From:
Sent: 06 March 2024 00:34
To: DCAdmin
Subject: Regarding Planning application 2023/93805

I wish to comment on the above application specifically in regard to the effect on the public footpath which crosses the proposed application area.

Drawing Title:
**EXISTING AND PROPOSED PROW
GENERAL ARRANGEMENT**

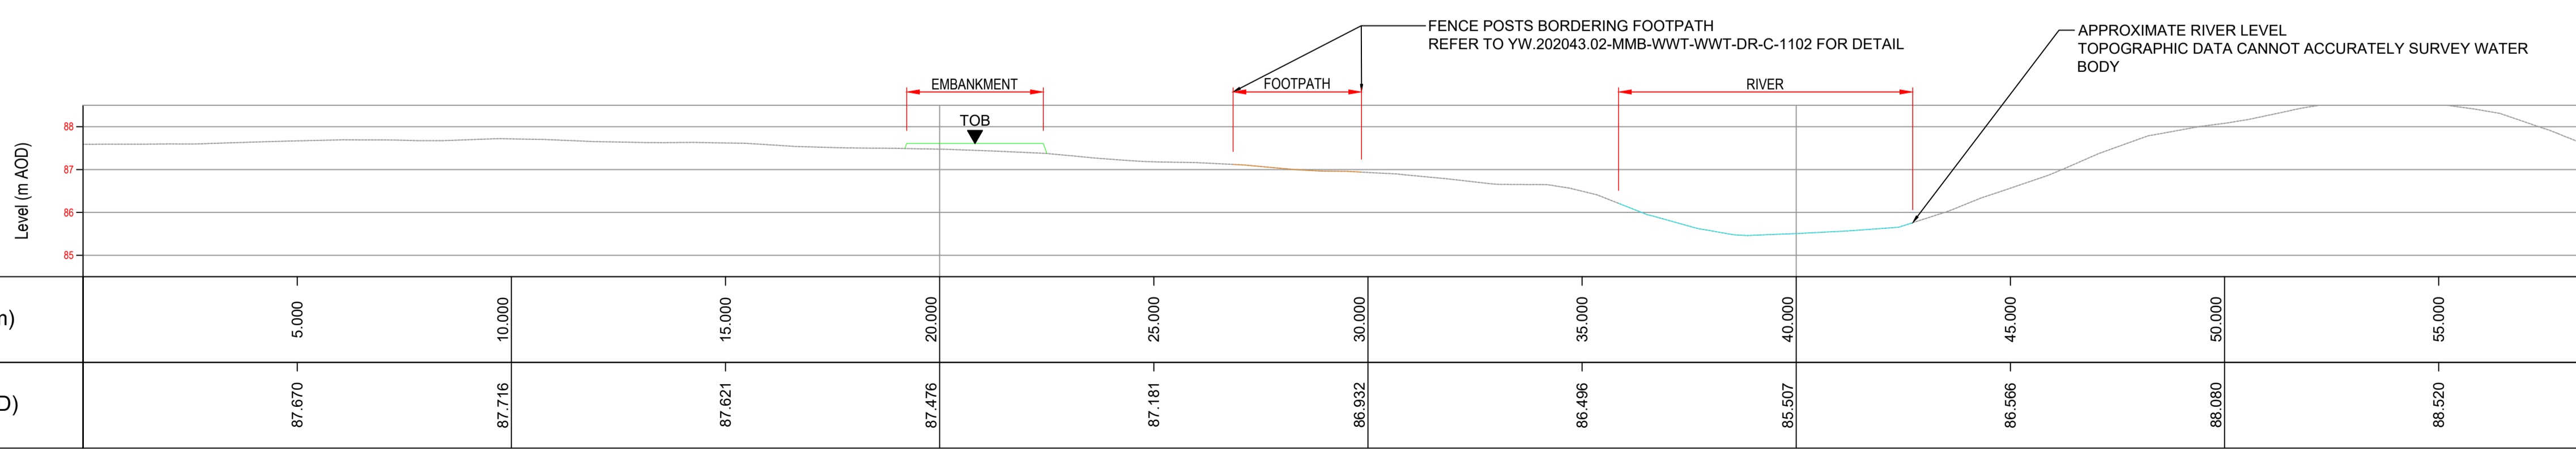
An additional planning notice dated the 22nd of February 2024 has been posted which states the works will affect a public right of way. (No. DEN/13/10, DEN/div13/10, DEN/15/40, DEN/15/30, DEN/13/20. DEN/15/20) Reviewing the proposed plans, none of them indicate any provision for the footpath which forms part of the Dearne Way.

This footpath must be maintained and kept open even throughout any planned works.

Only one of the published plans shows the current route of the footpath it is then never mentioned again even as a proposed closure.
